MONA OFFSHORE WIND PROJECT

Annex 7.6 to the Applicant's response to the Procedural Deadline

Figure updates to address inconsistency between Onshore Works Plan and Environmental Statement figures (Volume 7 – Part 3)

Document Number: MOCNS-J3303- RPS-10238

Figure 1.1: Water vole study and survey area.

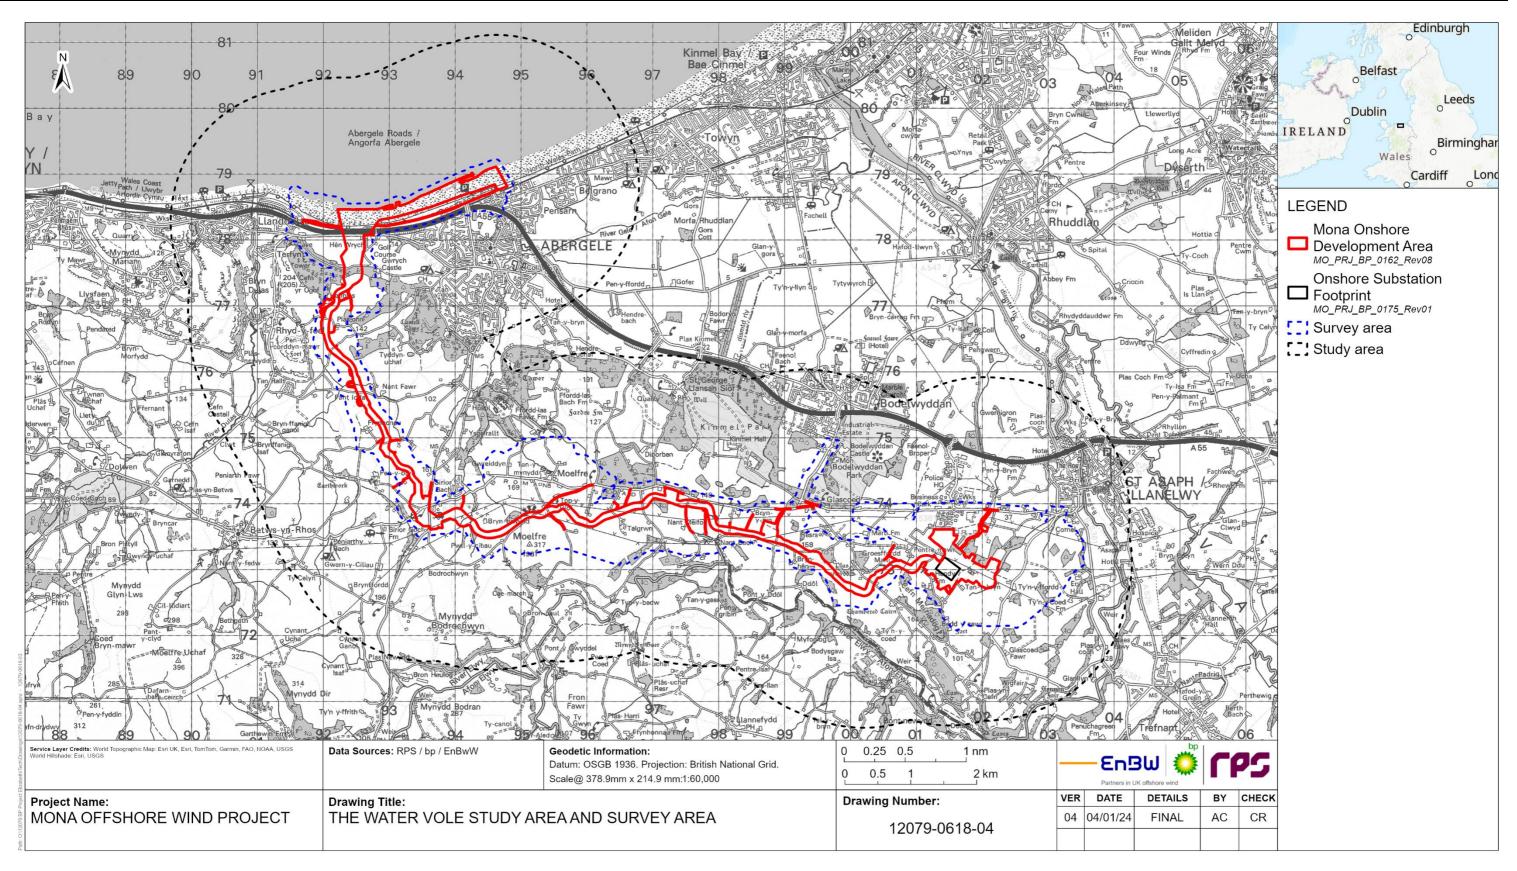
Para 12.1 of the Application Letter (Doc A1) states that the proposed operational access to the existing National Grid Substation from the proposed Mona Substation access from Glascoed Road has been assessed in the Environmental Impact Assessment (EIA) but part of it is not currently shown on all the EIA figures.

The Inspectorate advises the Applicant to undertake a thorough audit of the ES figures to ensure that they are consistent with the Onshore Work Plan (Doc B3). Amended ES figures should be provided, together with a list of the figures subject to amendment.

- 1.2.1.1 The Applicant has updated the figures of the Environmental Statement and other relevant application document figures as appropriate to show the proposed operational access to the existing National Grid Substation from the proposed Mona Substation access road. The figures that have been updated is provided below.
